Re: Dogger Bank South Project Targeted Non-statutory Consultation – Written representation (deadline 29/1/25)

I am responding to the above consultation as an Interested Party (20050002) and providing some feedback on the proposed changes/ current version of the proposal. I am a local resident of [REDACTED] who is particularly interested in the impacts of the overland cable route on ancient woodland and veteran trees, particularly Burton Bushes/ Beverley Westwood (a unique site and very popular nature amenity area for the public), both as a community area, as a unique habitat and in terms of archaeological interest.

- Onshore Order Limits
- Sheet Boundary
- Sites of Special Scientific Interest (SSSI)

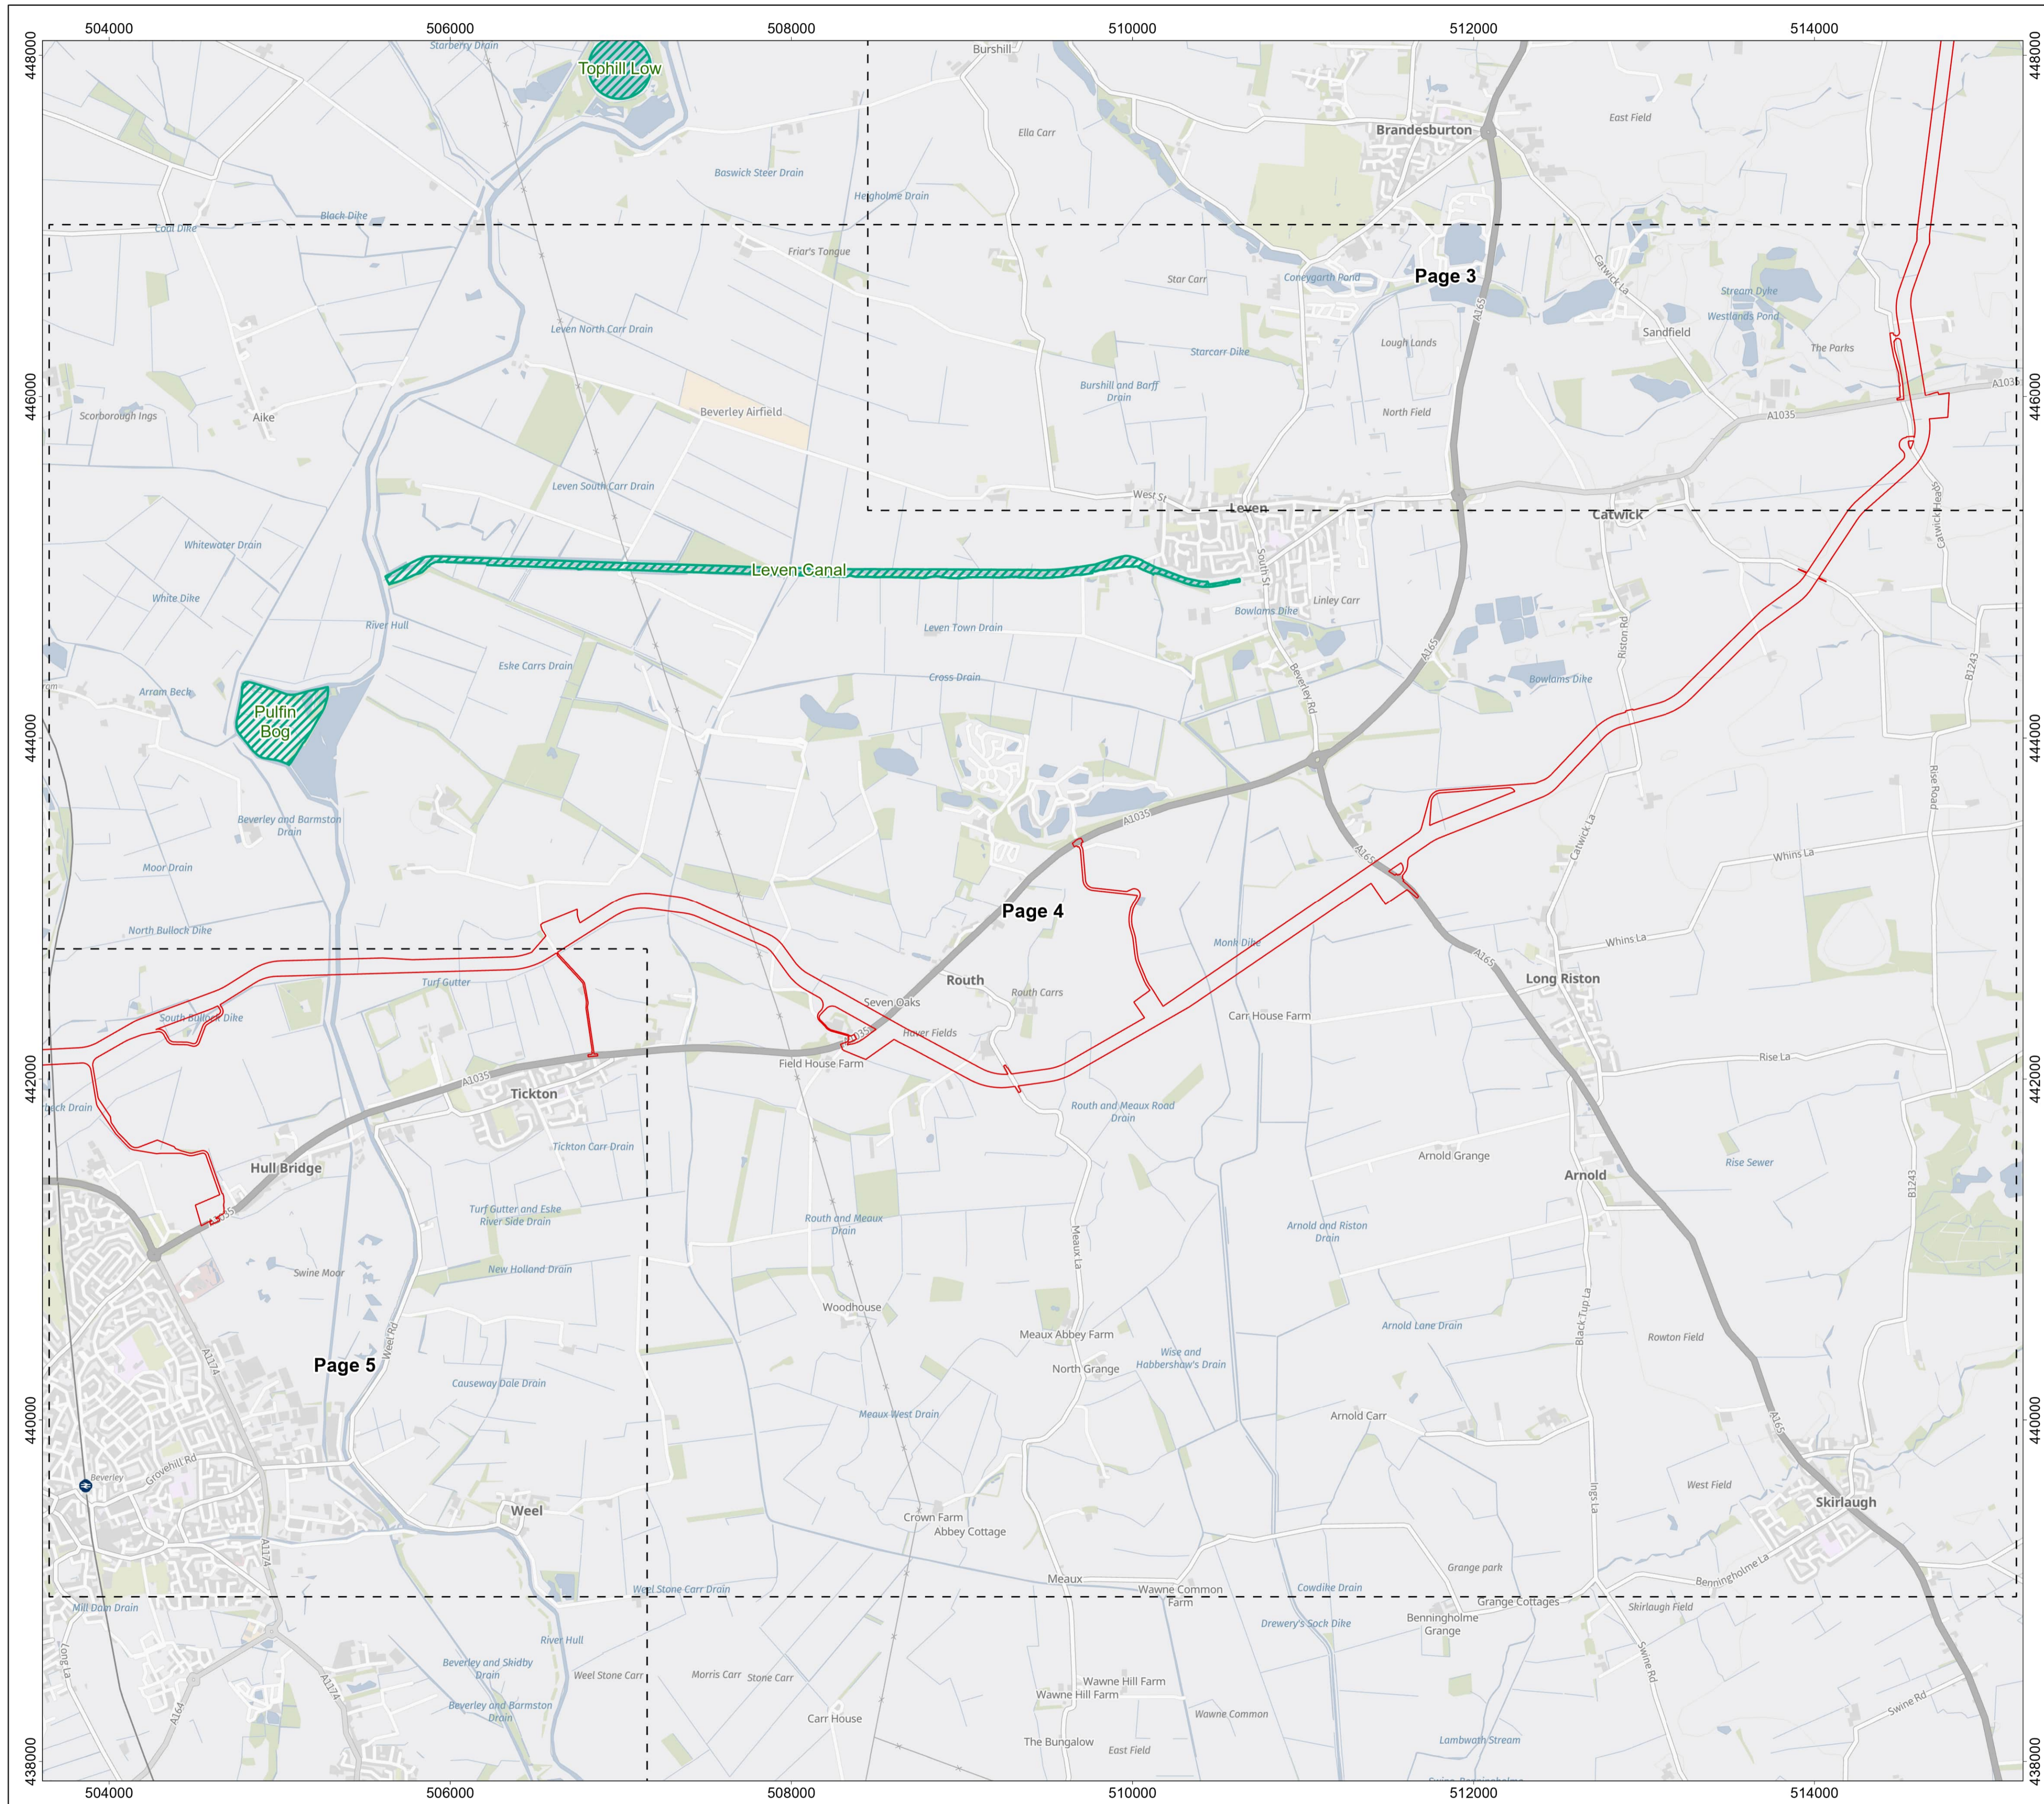
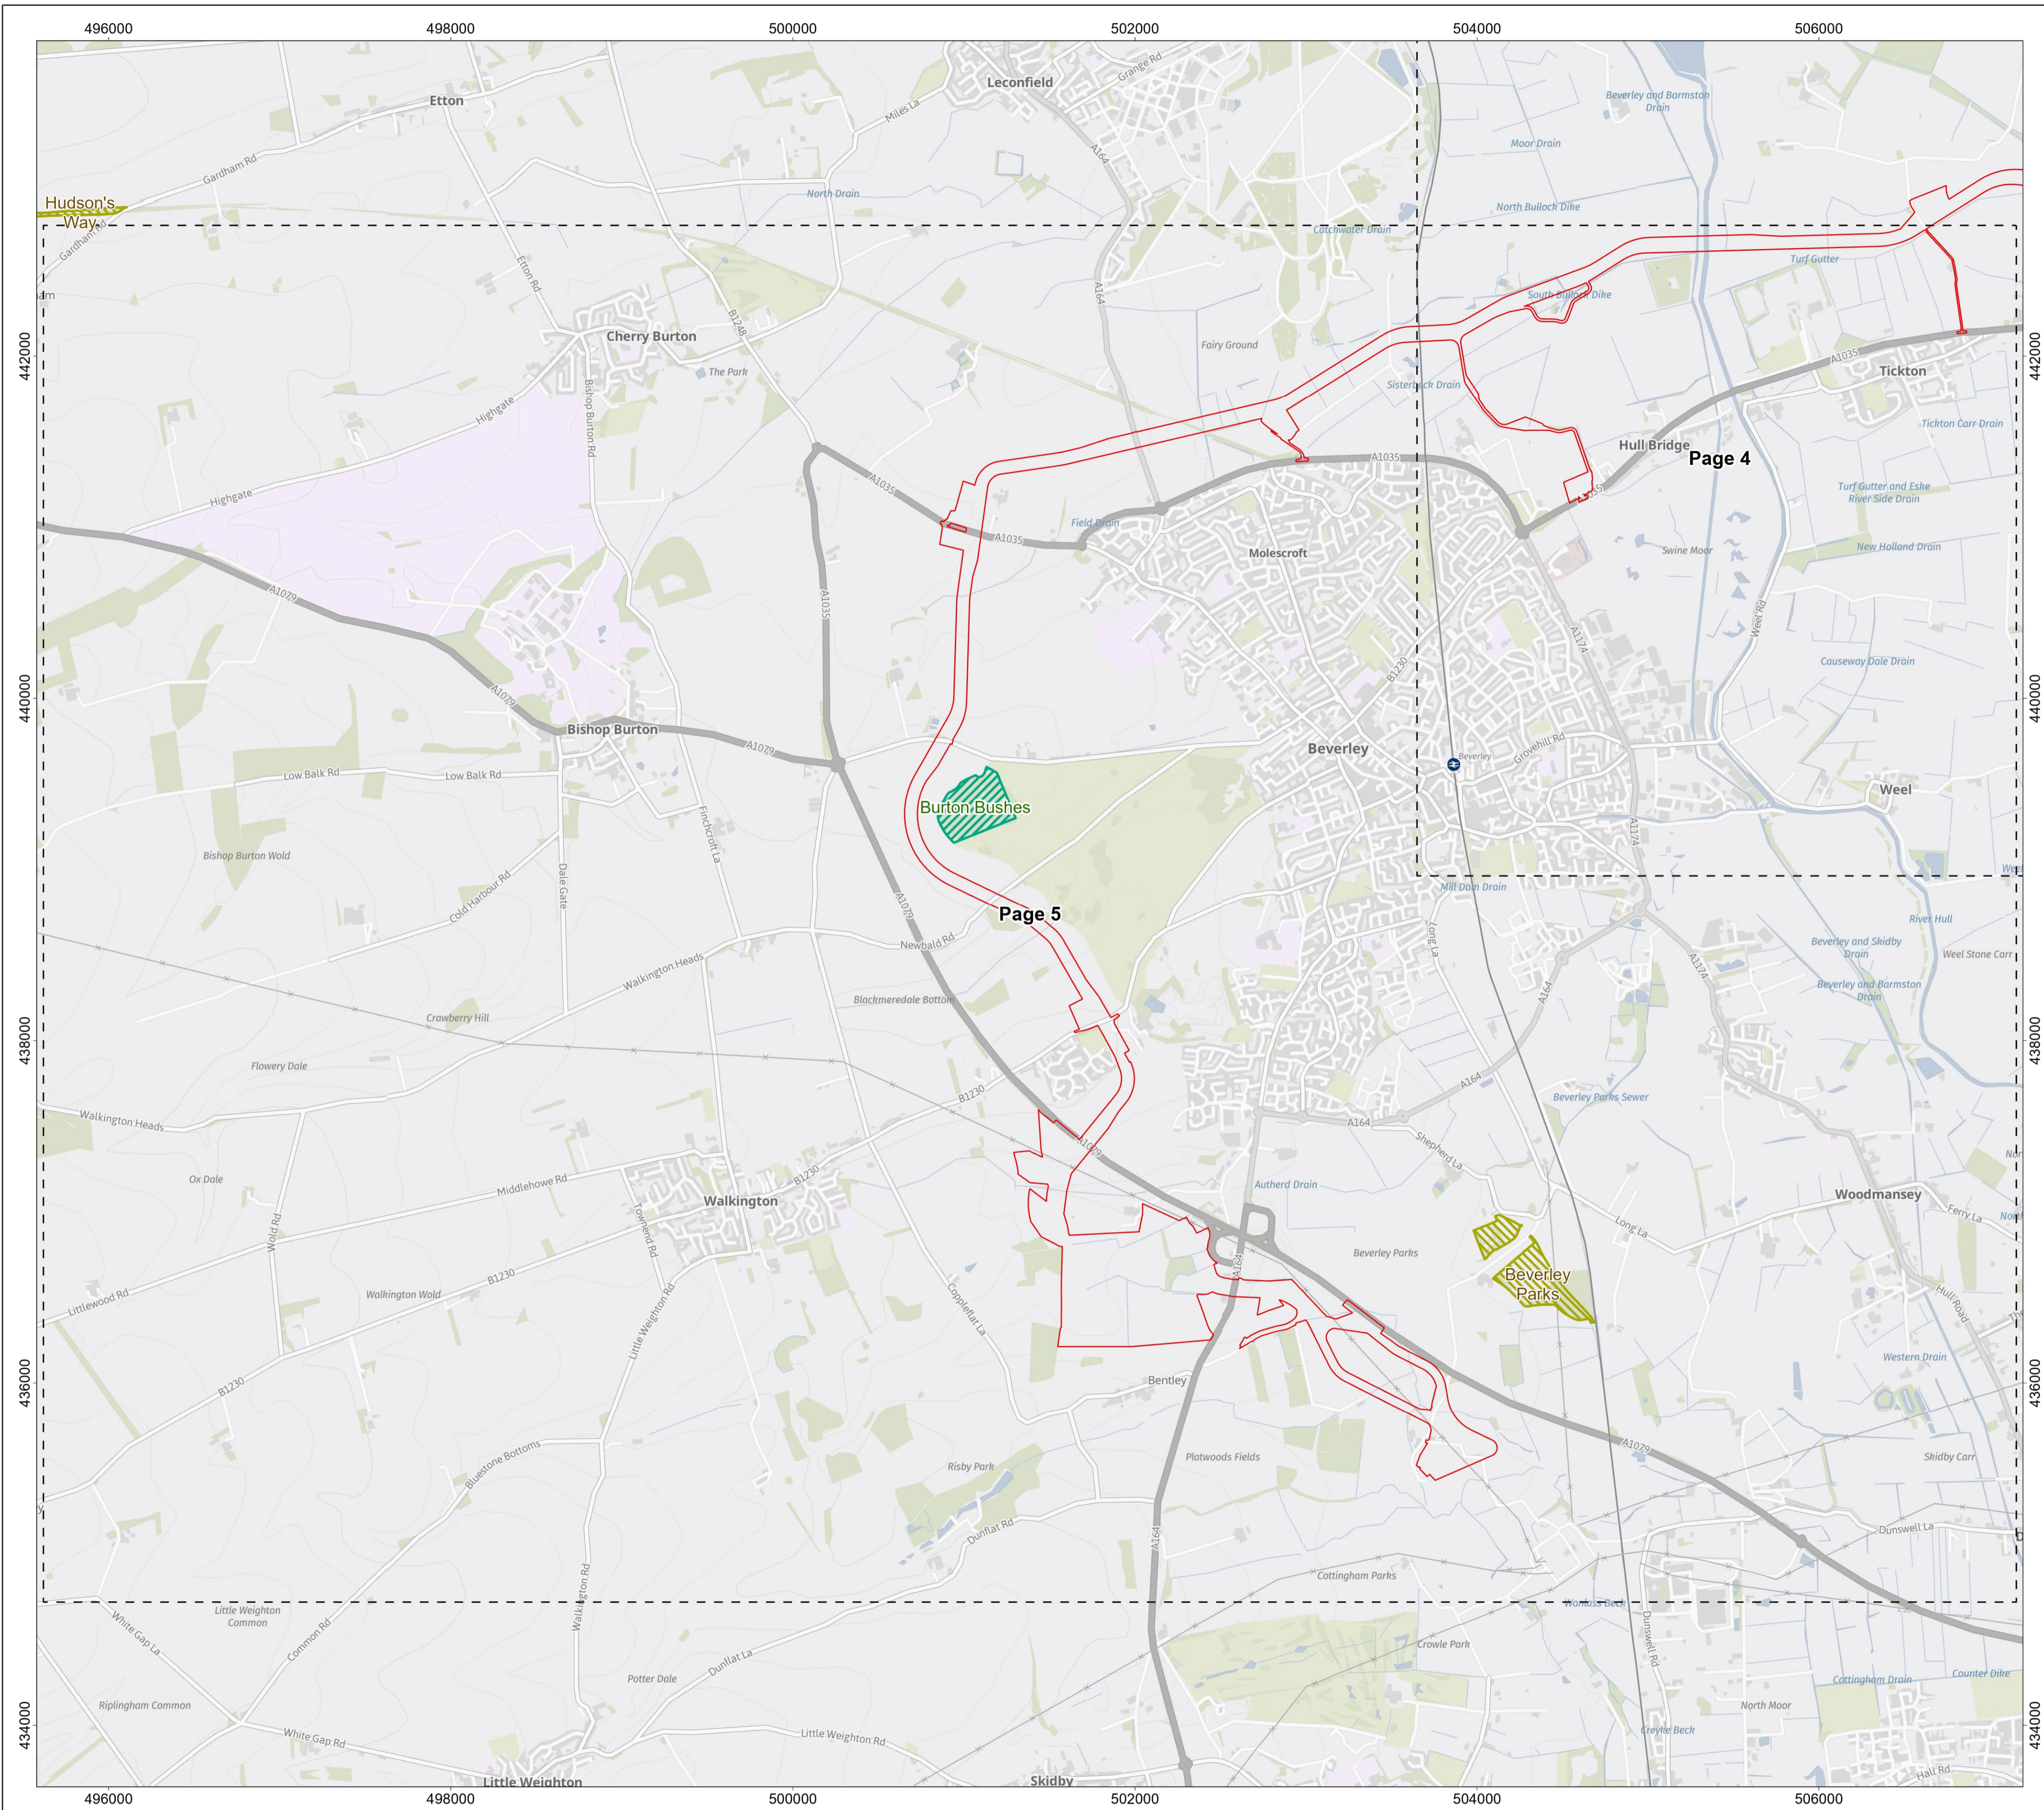
Comment: Can RWE confirm there is no drilling under Burton Bushes or the Westwood? This does not seem to be on the map and should not be allowed.

Whilst the adjustments described in the first two points are welcome, I still contend that the corridor and construction sites and buildings are too close to wildlife habitats/ archaeological SSIs to me (e.g. Burton Bushes) and general peaceful amenity areas on

the Westwood. There appears to be quite a lot of construction of 'temporary construction compounds' near to or next to various parts of the Westwood. The York road will be significantly disrupted.
